An Coimisiún Pleanála: FD04-324278/ ACP-324278-26

Re: Application under section 37L of the Planning and Development Acts 2000-2021 for Further Development consisting of further quarrying of rock along with all associated site development works at Ardcahan, Dunmanway, Co. Cork. The application is accompanied by an Environmental Impact Assessment Report and Natura Impact Statement.

An Coimisiún Pleanála Ref. No:	FD04.324278
Applicant:	Murray Bros. Tarmacadam
Site Location:	Ardcahan, Dunmanway, Co. Cork.
Proposed Development as per ACP:	Application under section 37L of the Planning and Development Acts 2000-2021 for Further Development consisting of further quarrying of rock along with all associated site development works. The application is accompanied by an Environmental Impact Assessment Report and Natura Impact Statement.
Nature of Proposal	Section 37L of the Planning and Development Act, 2000 as amended for Further Development

ARDCAHAN QUARRY REGENERATION 37L PLAN

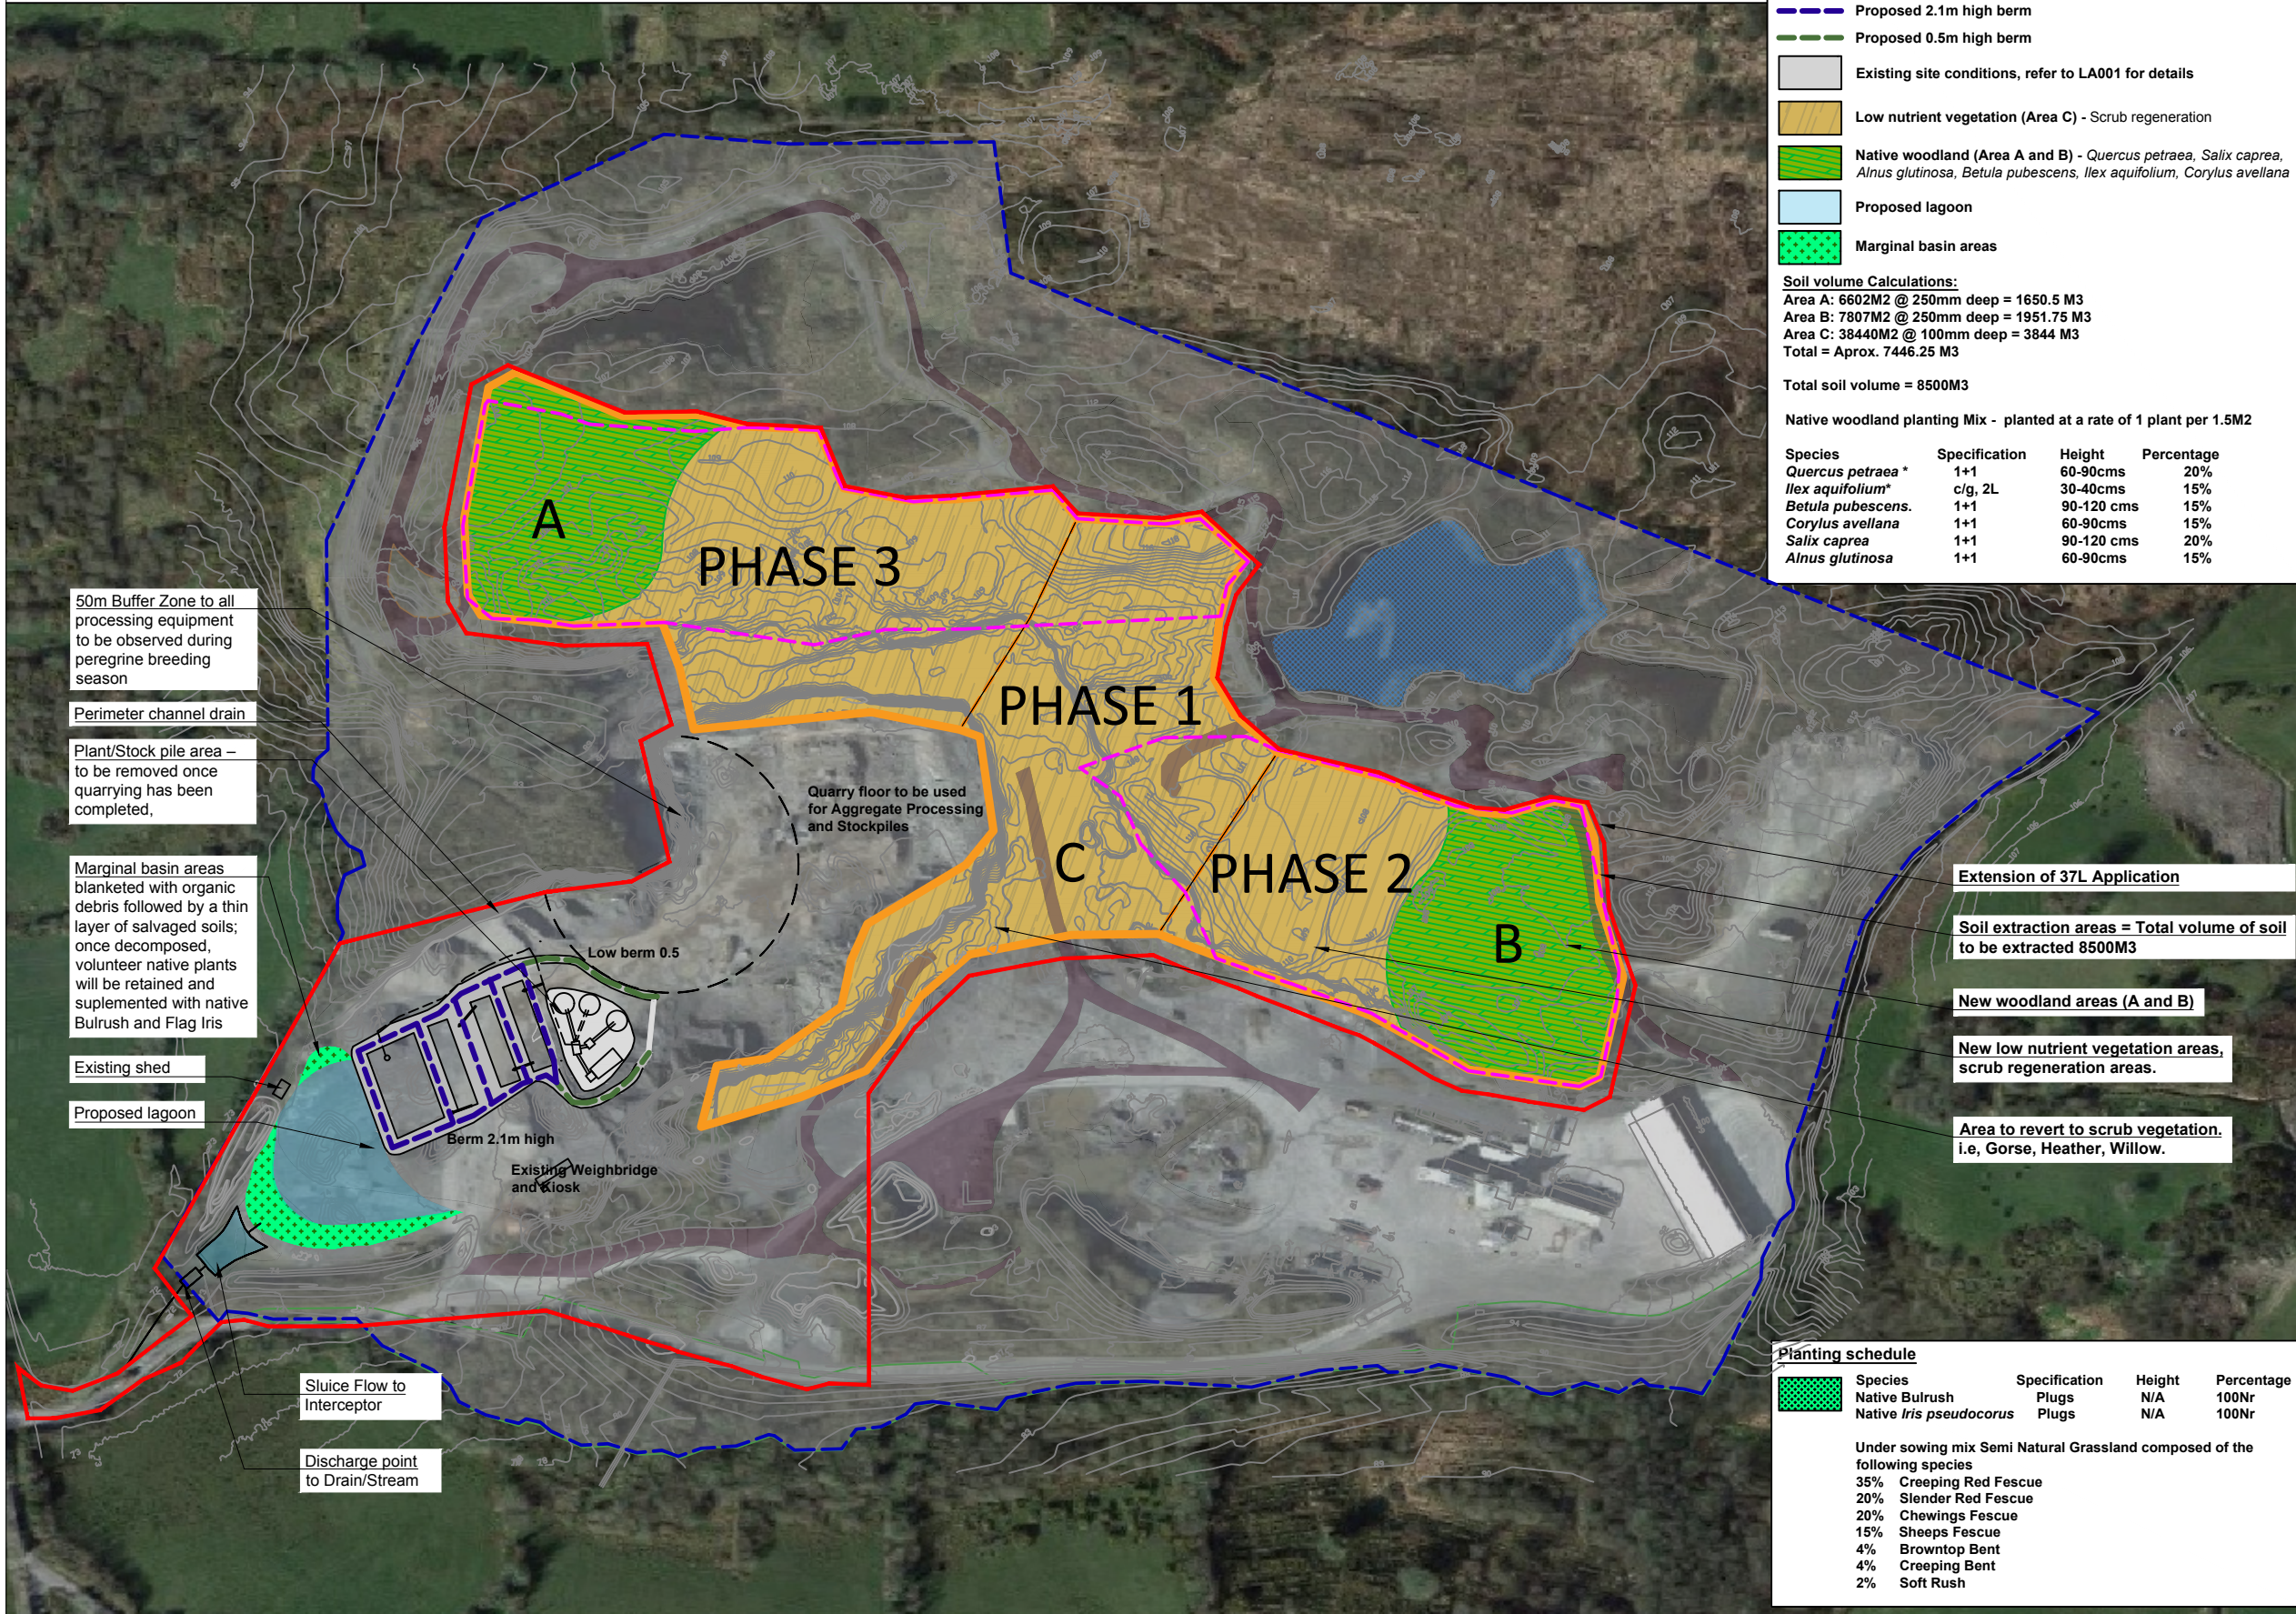
The Ecology Officer advises that the Regeneration Plan is not included in the Appendices (Volume III) and as a consequence, one drawing has been reviewed which details Areas A & B (new woodland areas) and Area C where scrub would be allowed to regenerate.

Notwithstanding this, concern has been raised with the proposed removal of further habitats of high ecological value for which insufficient detail in relation to post works remediation has been provided.

It is the Ecology Officer's view that land proposed for further development may be required to be incorporated into the remediation plan, together with proposals for active restoration of damaged habitats in this area, in order to achieve meaningful compensation for the extent of nationally important habitat which was removed from the site between 1990 and 2014.

The Ecology Officer advises that the issues relating to proposed habitat remediation for the substitute consent application, and the proposed Regeneration Plan associated with this application should be resolved before Appropriate Assessment can be completed. This is required as the resolution of these issues may, in the opinion of the Ecology Officer, require additional lands to be targeted for restoration and/or enhancement to adequately compensate for damage already incurred and to mitigate future projected impacts to habitats and species, potentially resulting in a necessary modification to the proposals for further development of this site.
